File No: SF18/95068
Ref No: DOC18/855443

Response to Modification request – The Sandstone Precinct 23-33 and 35-39 Bridge Street, Sydney (SSD 7484 MOD 3)

14 November 2018

LANDS BUILDING - LEVEL 01, EDUCATION BUILDING - GROUND

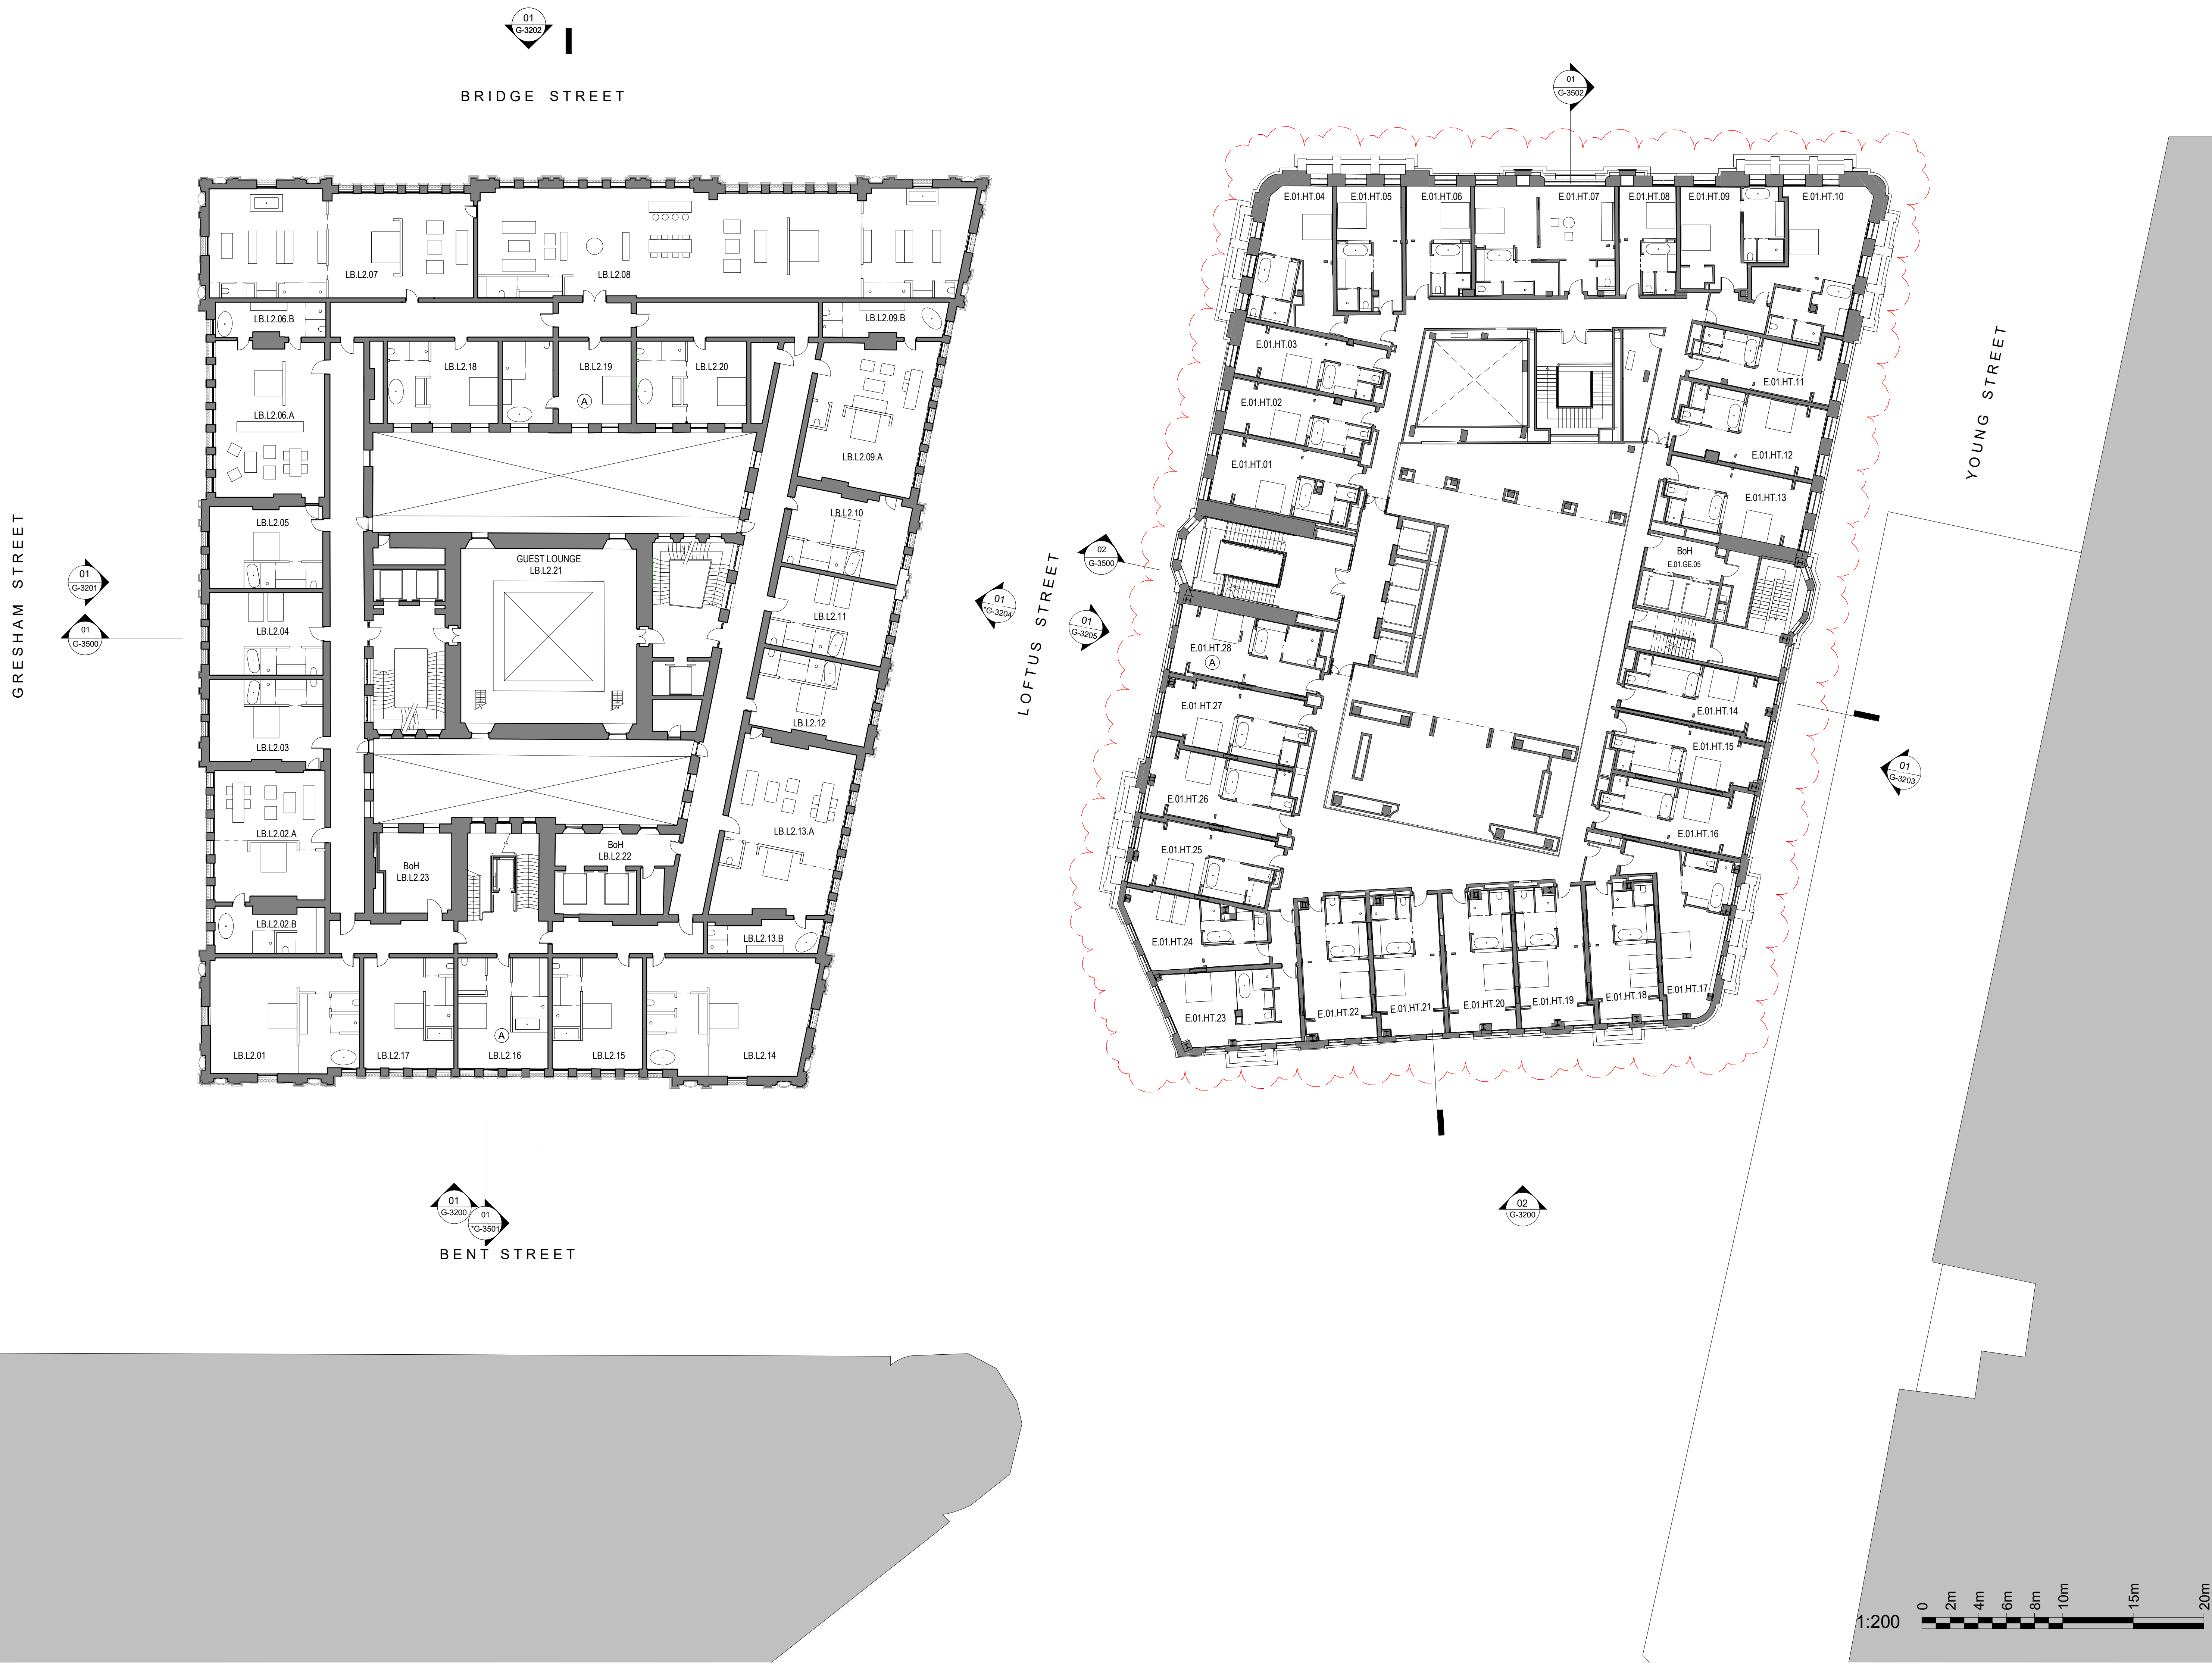
- The enclosure of three windows with the exceptionally significant façade to form the public bathroom requires a detailed design solution to mitigate adverse visual impacts when seen from the exterior (public domain). This would be best finalised in consultation with the project's heritage consultant, Jonathan Bryant.

- The creation of a new opening between Function Room 7 and 8 and the infill of the opening between Function Room 8 and 10 impacts fabric of exceptional significance. This requires a detailed design solution in consultation with the existing project heritage consultant. This solution should include the retention of substantial wall nibs and head, as well as a line in the flooring to interpret the original wall configuration.
- The Archaeological Research Design and Excavation Methodology in preparation for the overall site, be updated to include reference to the current revised basement excavation area works.
